Recommendation Report for Planning Permission

REF NO: F/7/19/PL

LOCATION: Waterbury House
Ford Road
Ford
BN18 0BH

PROPOSAL: 5 No. 1 bed flats together with staff accommodation, hard landscaping & parking (resubmission following F/10/18/PL). This application affects the setting of a listed building & is a Departure from the Development Plan.

Proposed South Elevation

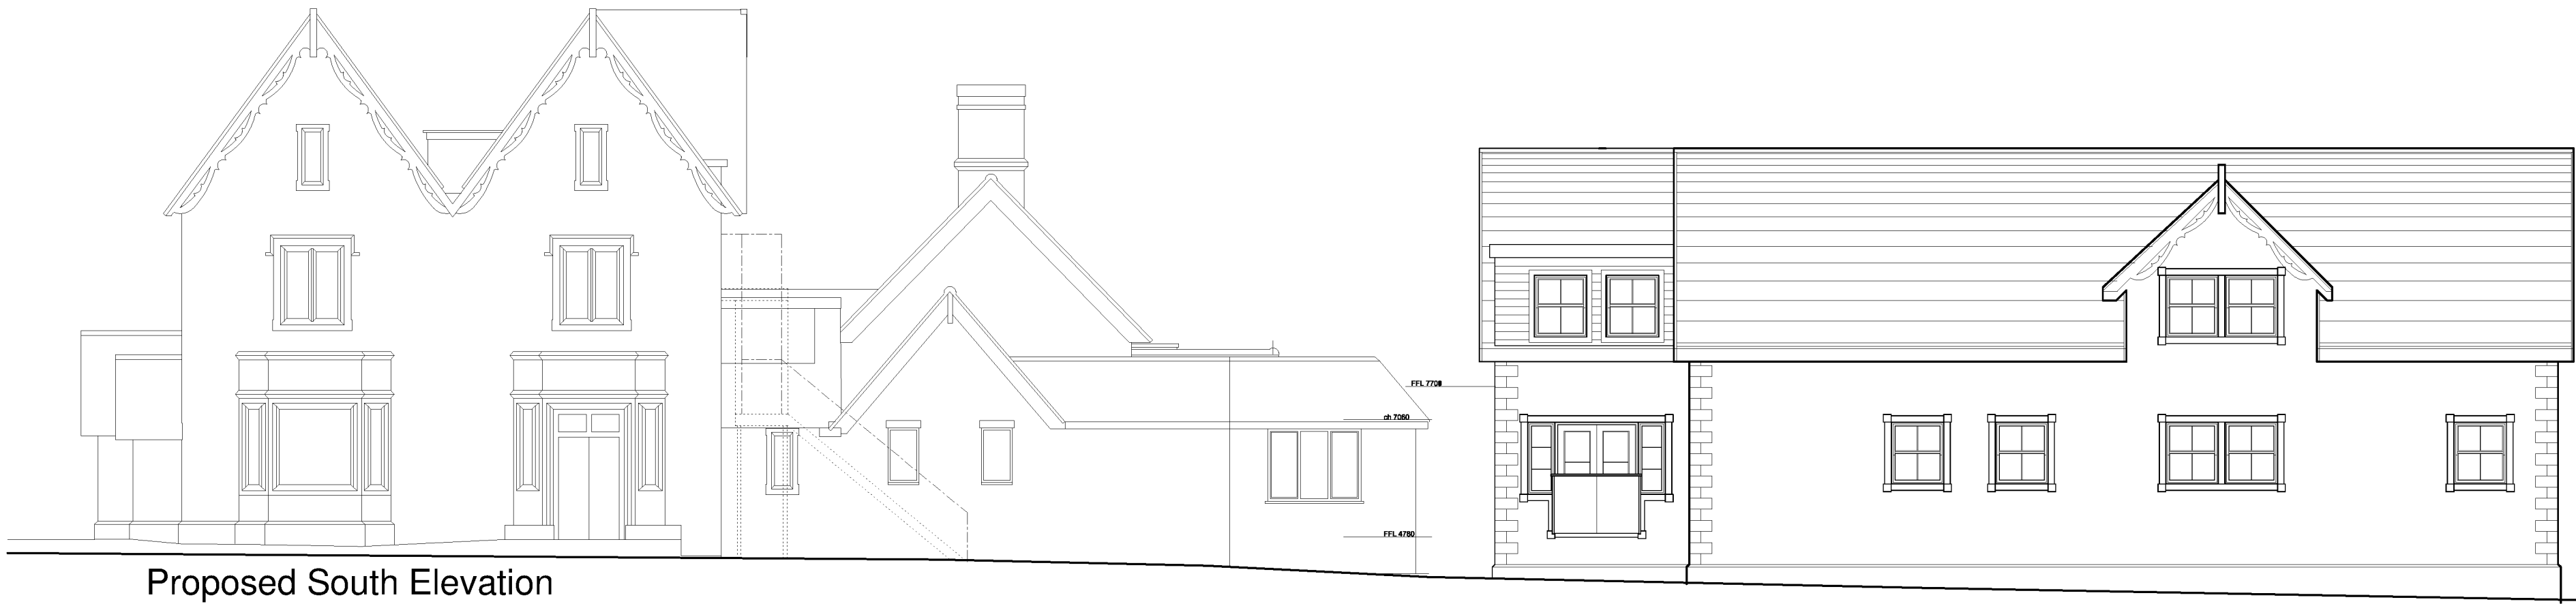
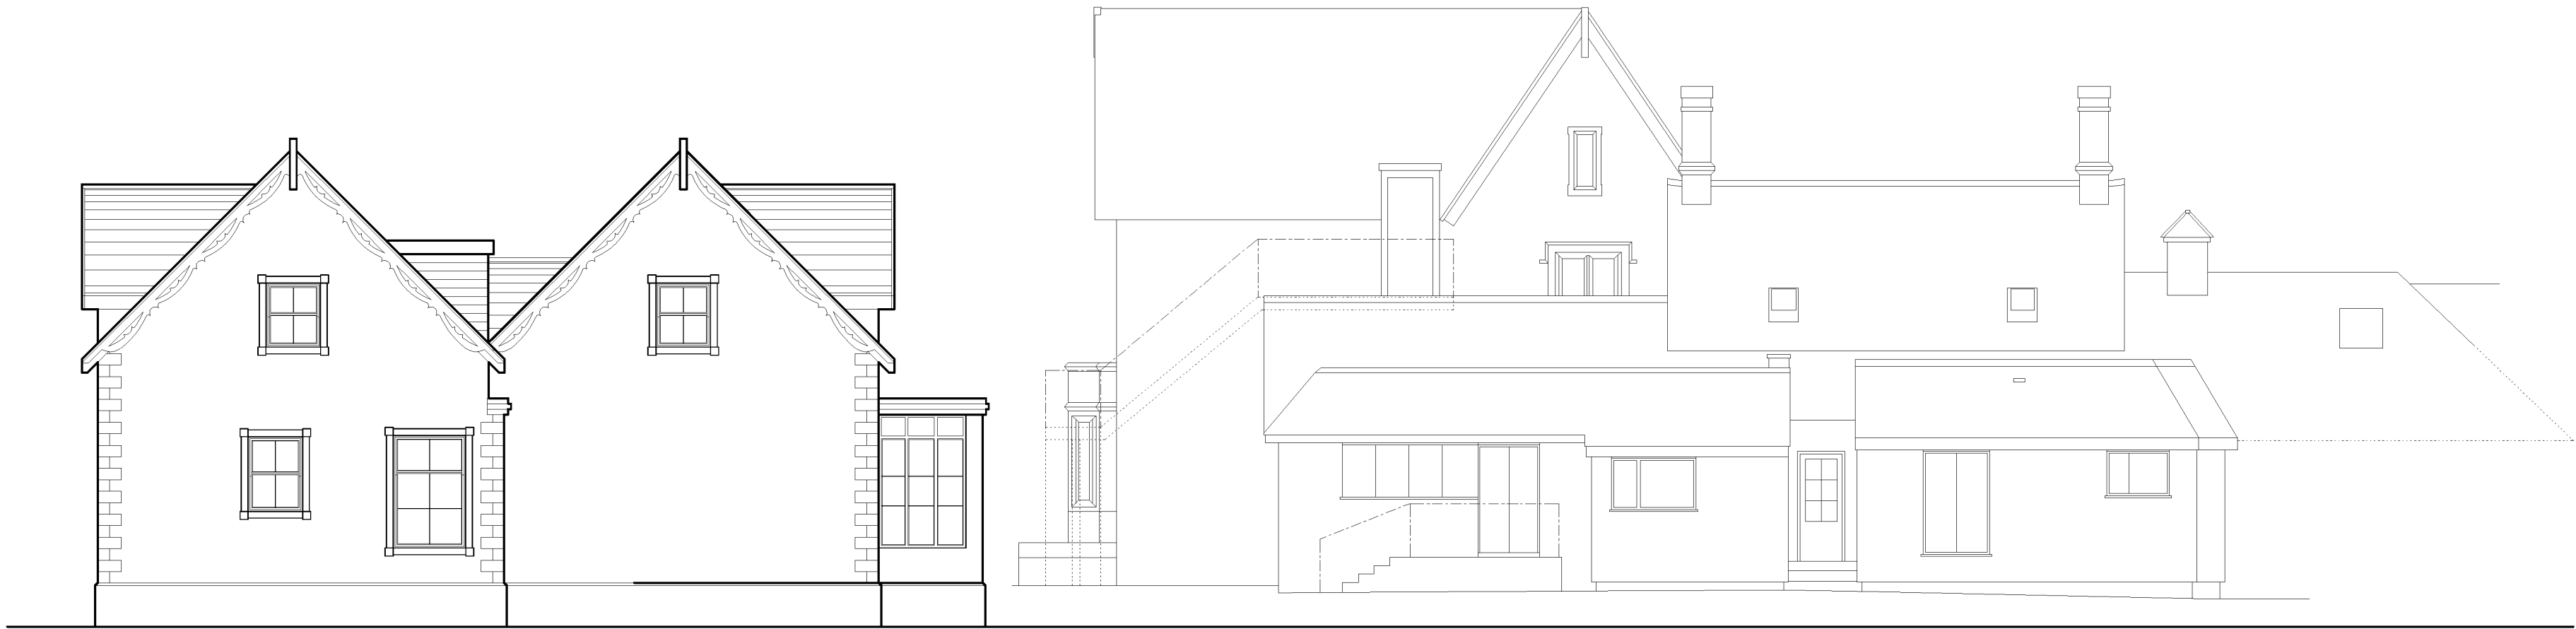
Objection- Having looked at the previous application and comments from Environmental Health this new application does little to address the concerns that were raised over noise affecting the occupiers of the proposed development.

The layout of the flats has been altered to move bedrooms away from the railway but living rooms are still located close to the railway and there is no protection of the outdoor amenity space from railway noise. This application has not included a noise assessment but earlier comments on the noise environment described in the previous noise assessment are still valid for this application.

However, with regard to occupiers of the units in the future it is noted that the building would be located 3m from the southern boundary with the railway line and 11m from the tracks. This close proximity means that the occupiers would be subjected to noise from trains using the railway line. The applicants have previously undertaken a noise assessment and the Council's environmental health officer was consulted. She objected to the proposal on the basis that the railway line would generate unacceptable noise levels which can't be appropriately mitigated and would adversely impact on the residential amenities of the occupiers of the units.

This was justified on the basis that the change from roof lights to dormers would result in additional noise penetration at first floor level and it would be reasonable to ensure these were double glazed and that alternative means of ventilation were provided where possible. The agents accepted the condition. It was considered unlikely that noise to the bathroom would adversely affect residential amenity and the units lounge area would be unlikely to be used for sleeping at night. No other windows served this area so alternative means of ventilation were difficult to achieve. With this current application the plans are annotated to refer to the use of double glazed windows and no bedroom windows are located at ground floor facing onto the railway line. The windows in this elevation serve en-suites and kitchens. Flat 3 has a lounge close to the railway line, but this has no windows directly facing the railway line. The windows face west towards the parking area. The closest lounge window facing the railway elevation is that flat 4 which is 10m from the boundary. Above this window is a bedroom to flat 5 with a window facing the railway line.

The most recent approval F/4/13 granted permission for a 4 bedroom unit which had one bedroom window at ground floor facing the railway line and a defined patio area which has been removed from the proposal. The internal floor layout is now less likely to result in noise nuisance to residents.

mitigated. The proposal would not therefore fully accord with policies DDM1 and QE DM1 of the Arun Local Plan, but there are other material planning considerations which prevent refusal on these grounds alone and further mitigation details are to be controlled by condition.
